WEST SUSSEX COUNTY COUNCIL CONSULTATION

TO:	Arun District Council FAO: Maria Tomalova
FROM:	WSCC - Highways Authority
DATE:	8 October 2020
LOCATION:	7 Ambleside Close Bognor Regis PO22 8NG
SUBJECT:	FP/179/20/PL 1 No 3 bedroom detached chalet bungalow. This site is in CIL Zone 4 and is CIL Liable as new dwelling.
DATE OF SITE VISIT:	n/a
RECOMMENDATION:	More Information
S106 CONTRIBUTION TOTAL:	n/a

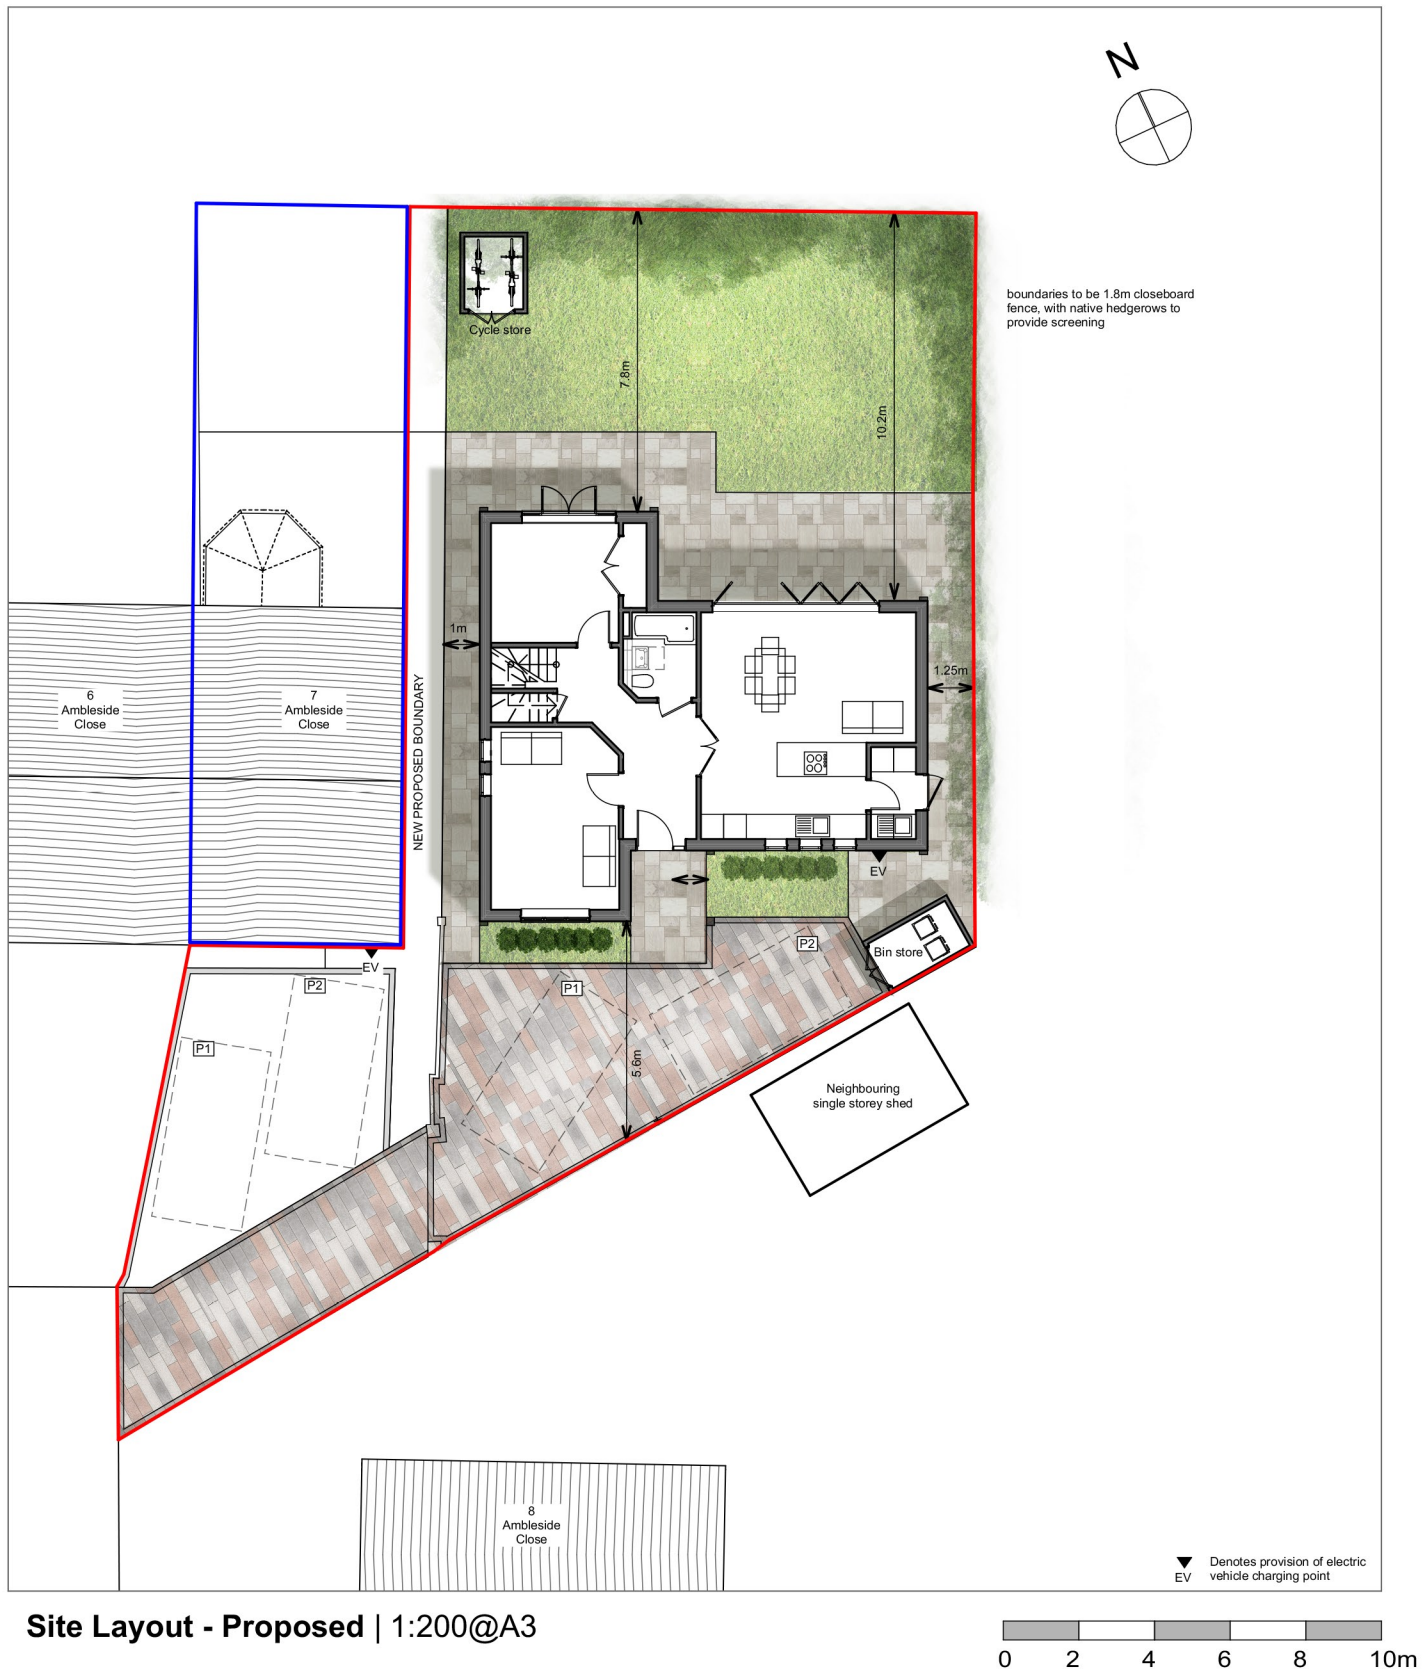
The proposal will utilise the existing access onto Ambleside Close, providing a shared driveway and two parking areas for both the existing and proposed dwellings. Whilst no visibility issues with the access arrangement are anticipated, the proposed driveway will be only 2.8m in width. It is unclear from the plans whether there will be an entrance gate to the proposed dwelling, the access width at this point appears to narrow to just 2.4m. The applicant should clarify whether an entrance gate is proposed.

The proposed parking area will provide two parking spaces for each dwelling, with no provision for vehicles to turn on site. The LHA note representations from neighbouring residents regarding the ability for vehicles to manoeuvre to and from the proposed spaces. The LHA request that the applicant demonstrate via swept path tracking that vehicles can sufficiently enter and exit each proposed parking space and can enter and exit the site from the public highway.

The applicant is also advised that the WSCC parking demand calculator expects a minimum of three parking spaces for a dwelling of this size and location. The applicant may wish to consider whether a third parking space could be accommodated on site.
